Our Ref: **AW/251/12/**
Your Ref:

Application for Planning Permission for Works or Extension to a Dwelling

Development Front extension
Location 34 64 Regis Avenue Aldwick —

Drawing
Location & Block Plan

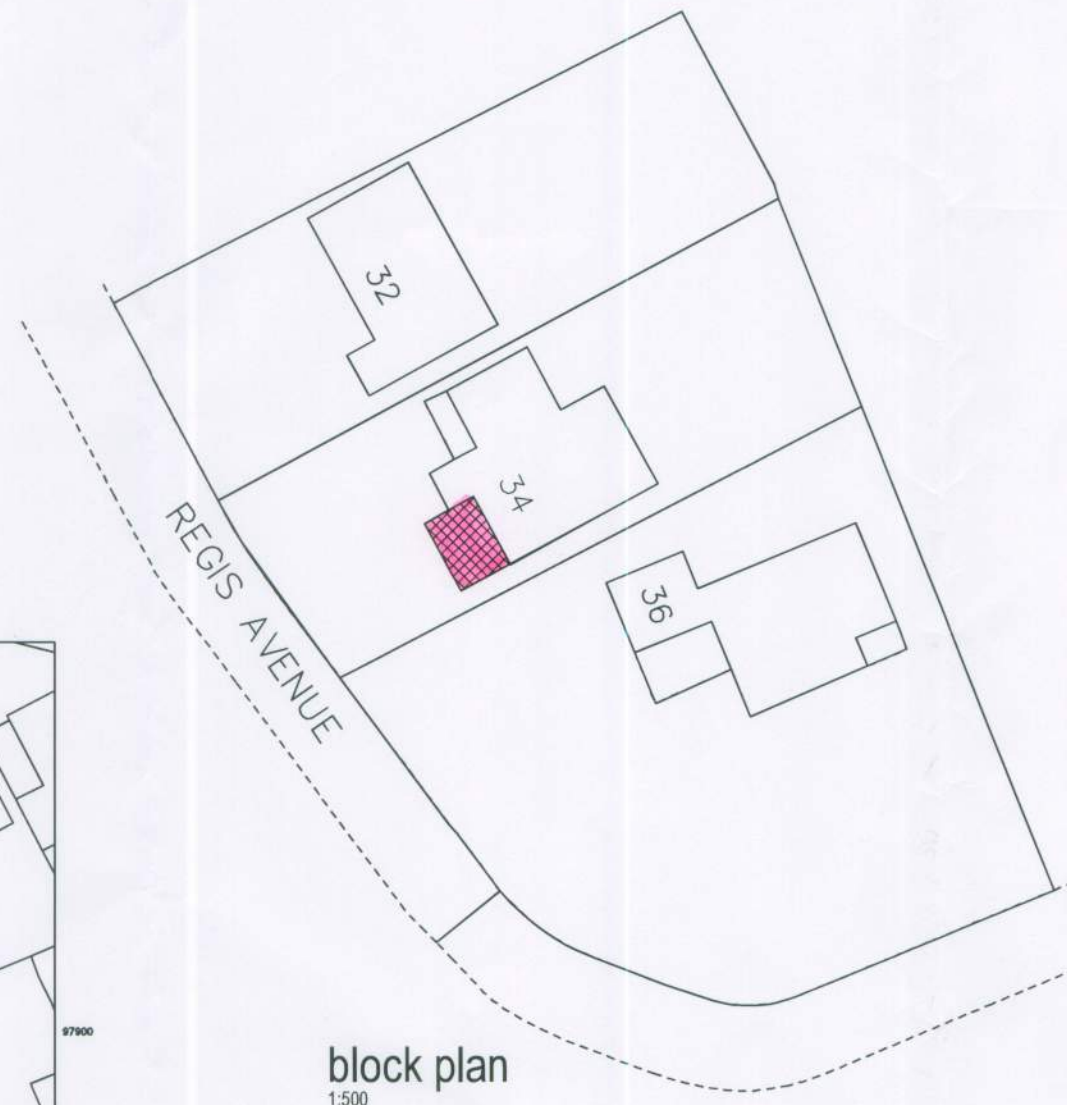
Please hatch/highlight the proposed works, please provide one named road and also show more properties that surround the site.
